CITY OF ALBUQUERQUE

November 2, 2017

Site: Paradise View Universal Apartments

Re: Drainage Ordinance (14-5-2-1) Violations for Erosion and Sediment Control

Inspections Plus Inc.
Erosion Control Plan
Standard Details

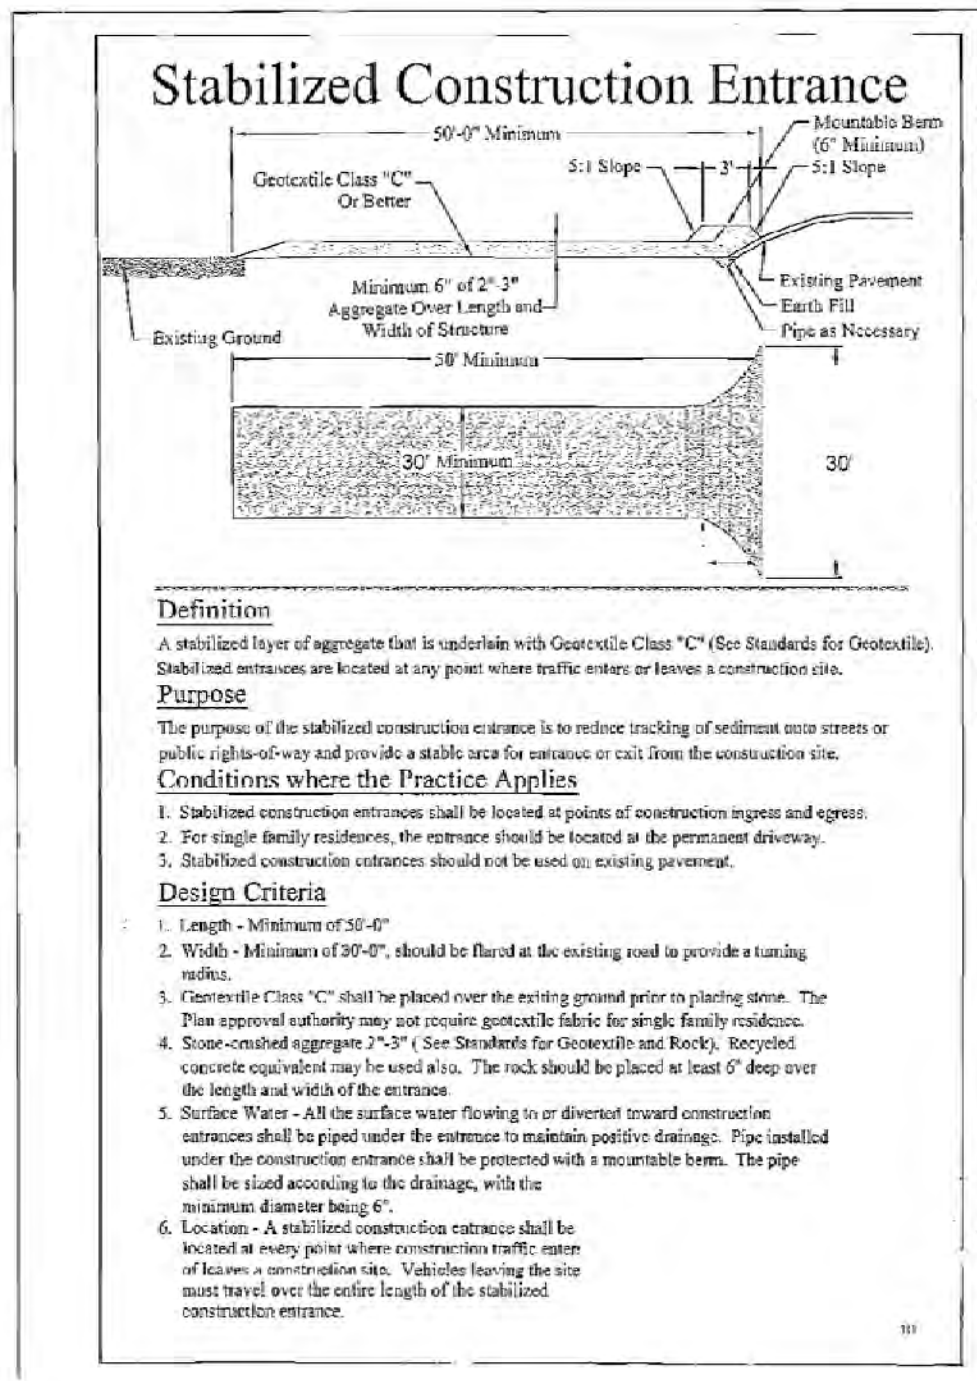
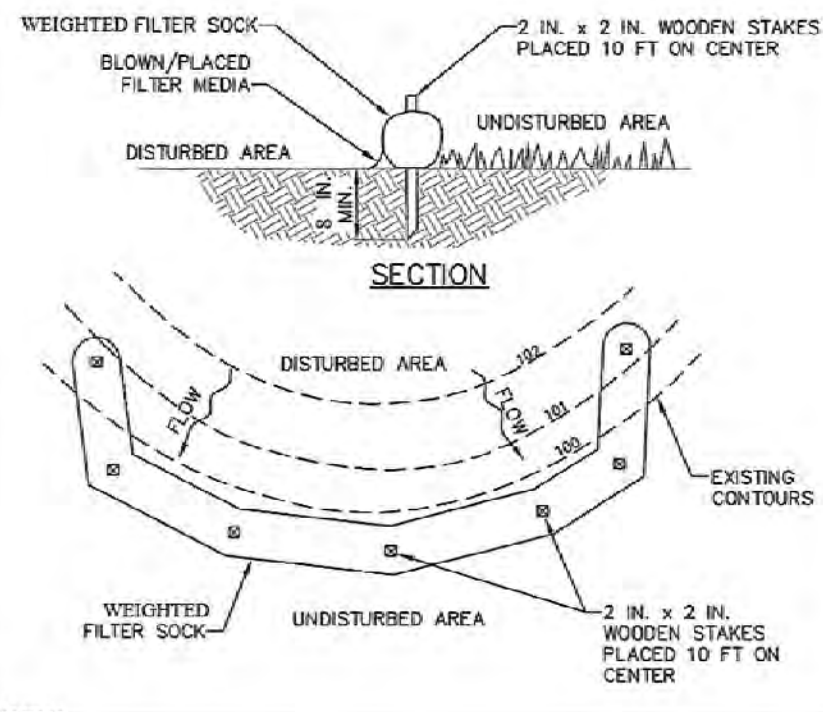
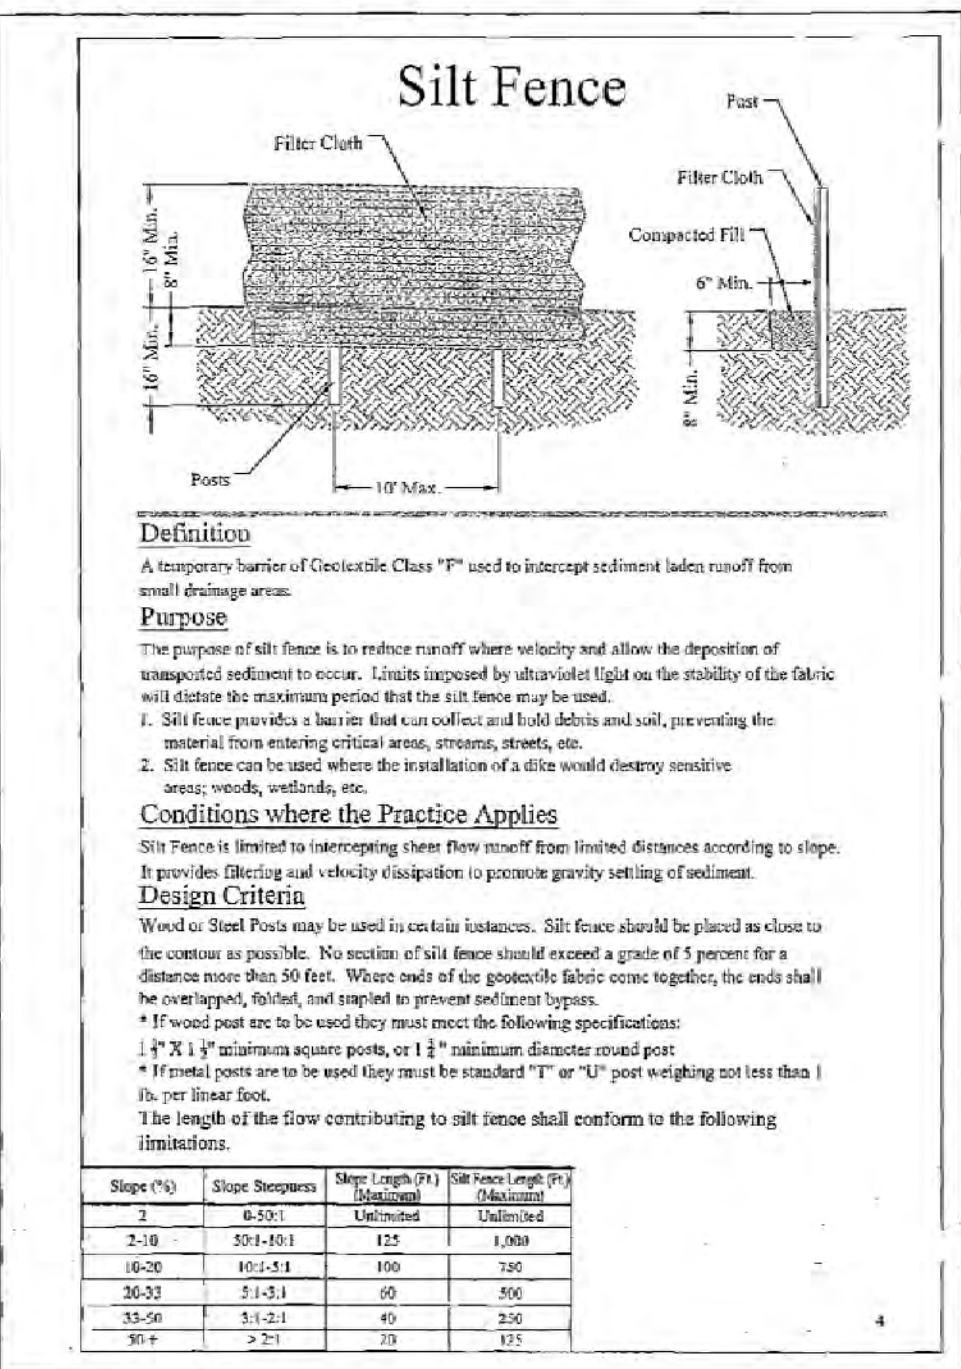
1. The project does not have an approved Erosion and Sediment Control plan or an Erosion and Sediment Control Permit.
2. A dirt ramp was being used to access the site.
3. Track-out pad was too short, required maintenance and there was considerable track-out from the site.
4. There was considerable disturbance outside the installed silt fence with no sediment BMP.

1. Submit an adequate Erosion and Sediment Control plan, that includes all disturbed areas, and have the plan approved. Obtain an approved ESC Permit.
2. Remove the dirt ramp that was being used to access the site.
3. Install a track-out pad per commonly accepted details.
4. Remove track-out on Sierra Morena St from the site up to the intersection with Rabadi Castle Ave and on Buglo Ave.
4. Provide sediment BMPS for or stabilize disturbed areas.
